From: Sian Eggington <[REDACTED]>
Sent: 15 November 2018 14:56
To: Sian Eggington
Subject: FW: AB/121/18/HH
Attachments: 35 Maltravers Street, Arundel - planning-DPA-01 rev02.pdf

From: Chris Pope [REDACTED]
Sent: 15 November 2018 14:50
To: Sian Eggington
Subject: RE: AB/121/18/HH

PROPOSED SECOND FLOOR PLAN
SCALE 1:100

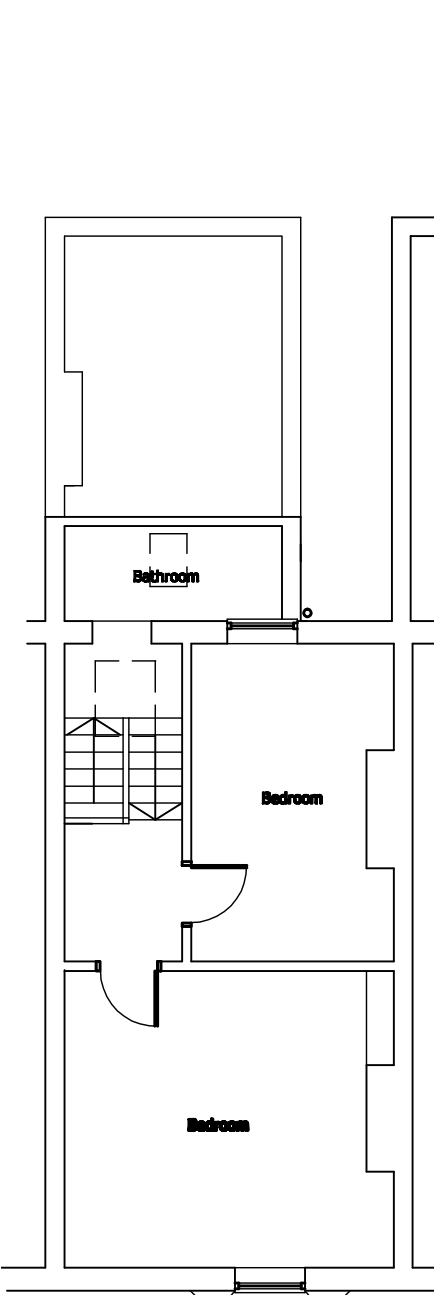
Thank you for your email however please can you confirm whether the bathroom on the second floor is a new extension or whether it is being built into existing roof space and please show this on the section drawing.

It's with in existing roof space

PROPOSED CROSS SECTION
SCALE 1:100

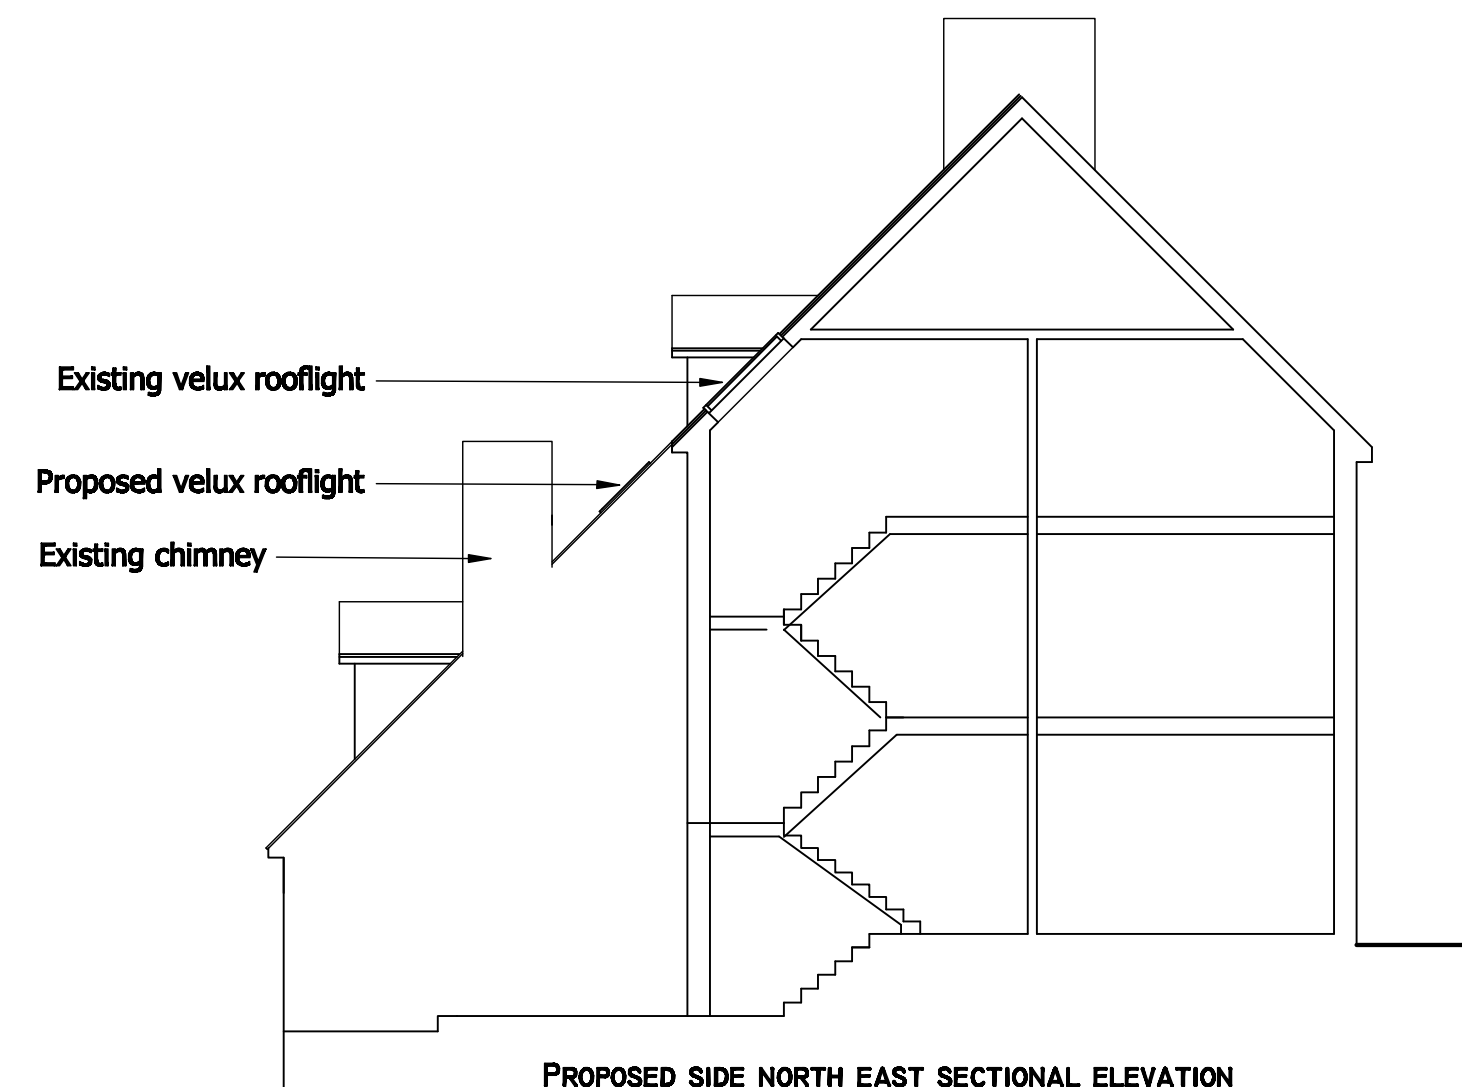
Thanks for confirming. Can this be shown on the proposed section.

Proposed section added to attached drawing showing bathroom location.
